**CITY OF PORTLAND, MAINE
DEVELOPMENT REVIEW APPLICATION
PLANNING DEPARTMENT PROCESSING FORM
DRC Copy**

2004-0217

Joseph Ave

RE: Joseph Avenue – 172-F-001, 002, 003 – R-3 zone – new single family dwelling – permit application #04-1585

BOUNDARY SURVEY

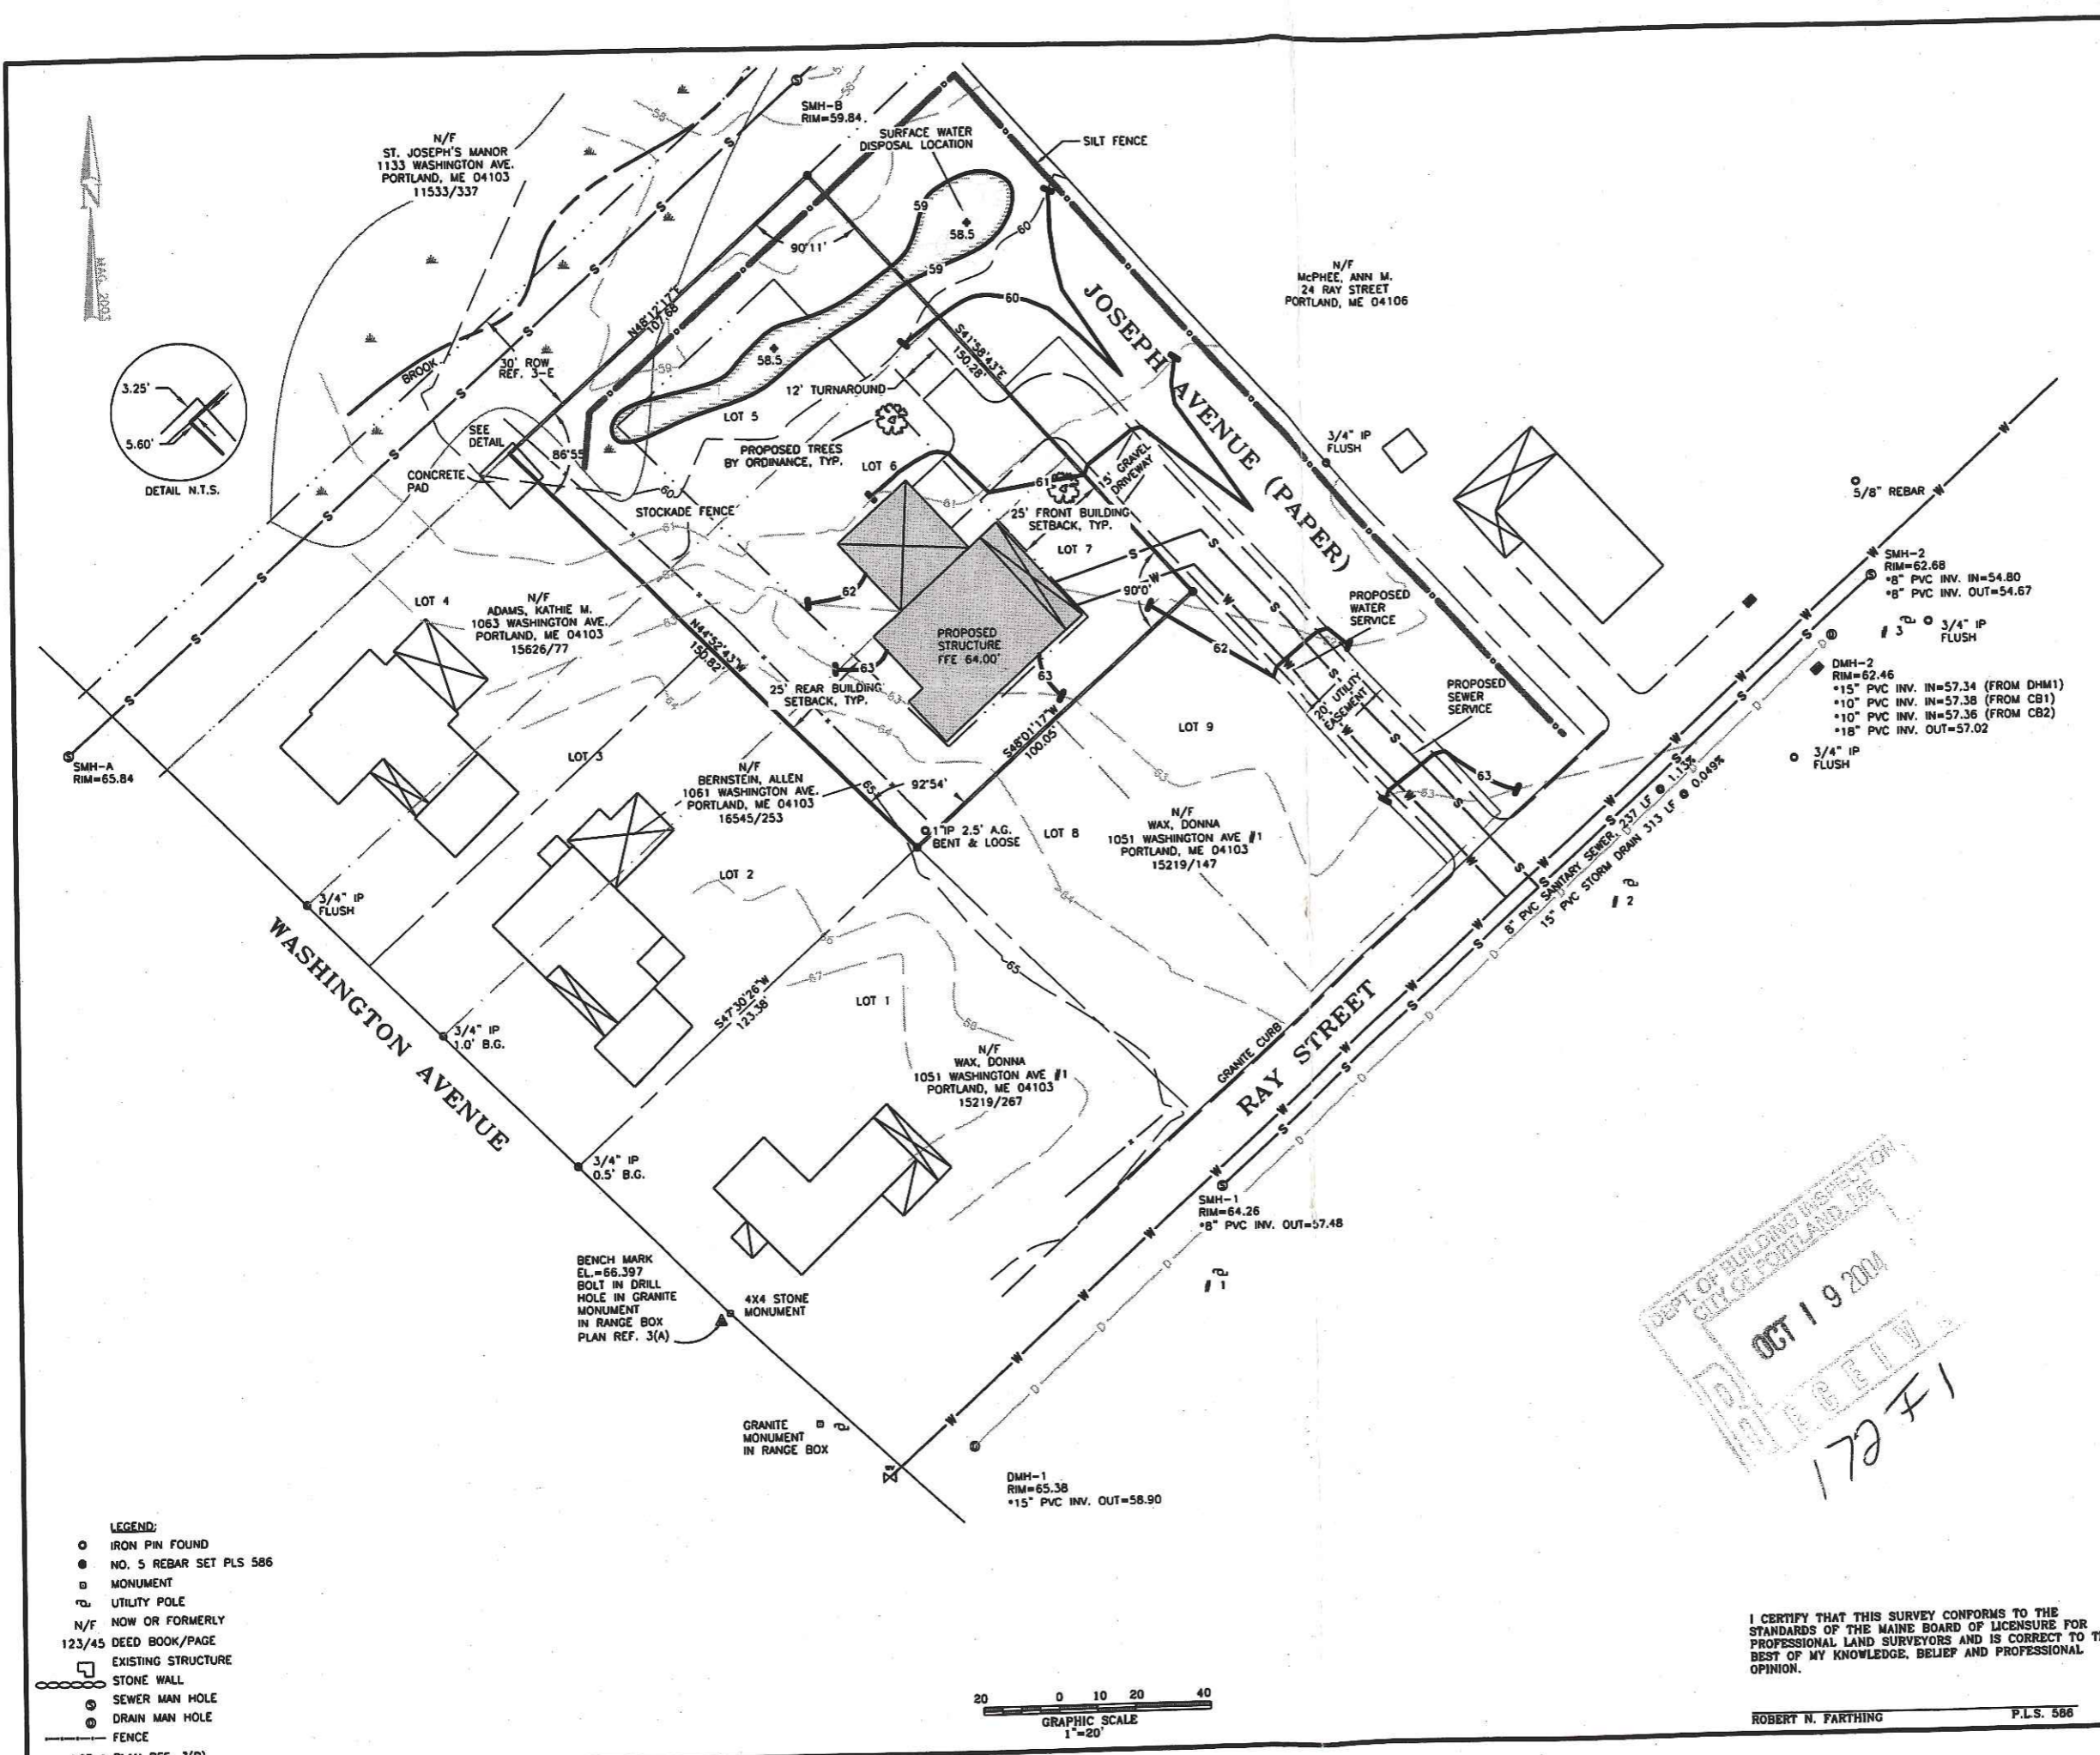
First, your site plan does not match your building plans. All dimensions shall match before a permit application can be adequately reviewed. It is also noted that there is a rear sliding door with no rear deck or stairs being provided. ALL structures that are to be approved as part of this permit application SHALL be shown on both the site plan and the structural plans.

Secondly, Joseph Avenue is a paper street as designated on your submitted plans. Section 14-403 of the ordinance states that the construction of a new housed shall trigger the requirement to upgrade the street to City standards. There is only one exception that this office has not received from you. Section 14-403 states, "The provisions of this subsection (b) shall not apply to the erection of any single-family dwelling on any lot where the owner of the lot establishes that he or she was the owner of that same lot on November 19, 1984, and at all times thereafter, and states his or her intention under oath to make the structure his or her personal residence". Your application submittal did not include such an affidavit. If you believe that all sections of the exemption allowance pertain to your application, it will be necessary to submit an appropriate affidavit to this office. If you cannot meet the requirements of the exemption, it will be necessary to show this office how Joseph Avenue is being brought up to City standards with the appropriate drawings.
